RECOMMENDATION FOR PLANNING AND DEVELOPMENT COMMITTEE

APPLICATION REF: 3/2026/0375

PROPOSED SYNTHETIC TURF PITCH, INCLUDING FENCING, ACOUSTIC BARRIER, FLOODLIGHTING, ACCESS PATH, TOILET BLOCK AND ANCILLARY EQUIPMENT AT PLAYING FIELD, EDISFORD ROAD, CLITHEROE, BB7 3LA

SITE PLAN WITH TREE OVERLAY

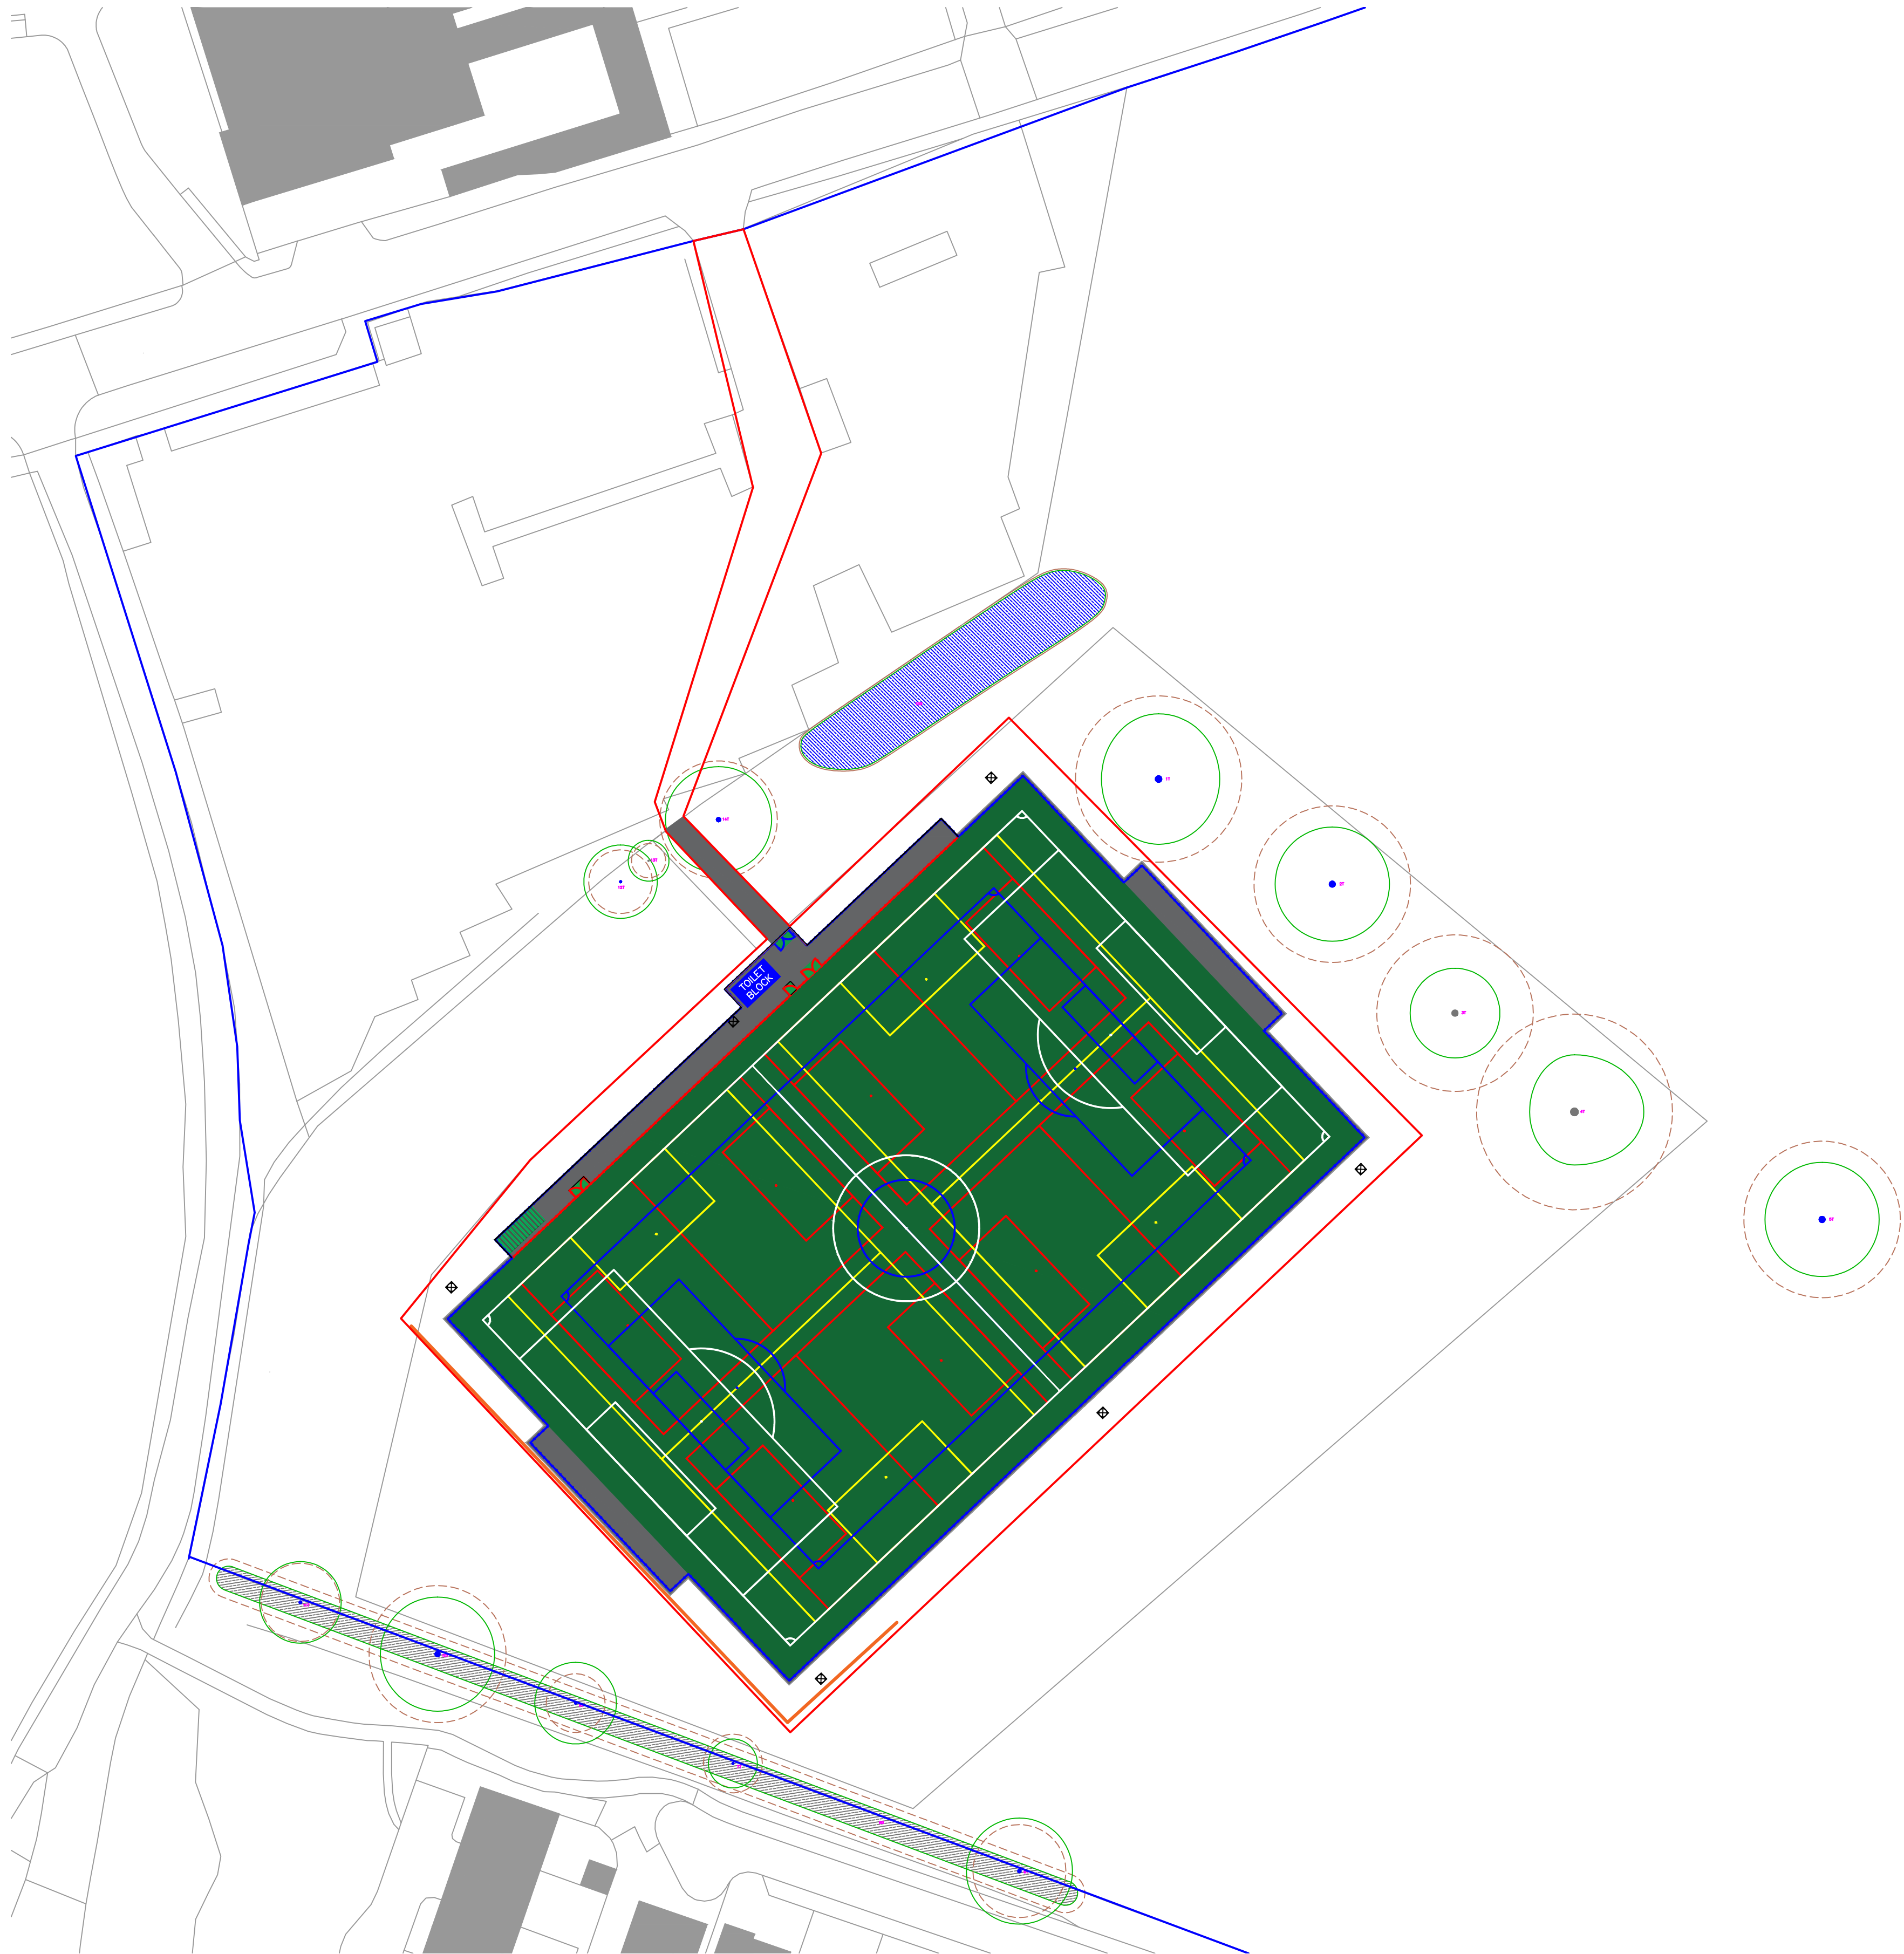
The Countryside Officer considers that the floodlighting would be acceptable. They note that there is some incursion into the RPA of tree T1 Sycamore and assuming that the pitch cannot be moved further away it would require a tree specific hand dig process for T1 as part of a tree protection condition for all trees identified on the submitted site plan with tree survey overlay details.

- 5.4.2 The Countryside Officer has provided comments on the scheme and notes that the development would extend into the Root Protection Area (RPA) of T1 which is a mature Sycamore tree. Having received the site plan and tree overlay plan submitted with the application, it appears that whilst the RPA is located within the red line boundary, it is not located within the area proposed for any works.

Notwithstanding this, the access path is to extend within the RPA of T14 which is a mature Ash Tree (Category B1). As such, it is still recommended that a tree specific hand dig process for this tree as part of a tree protection condition for all trees identified on the submitted site plan with tree survey overlay details be secured by way of planning condition.
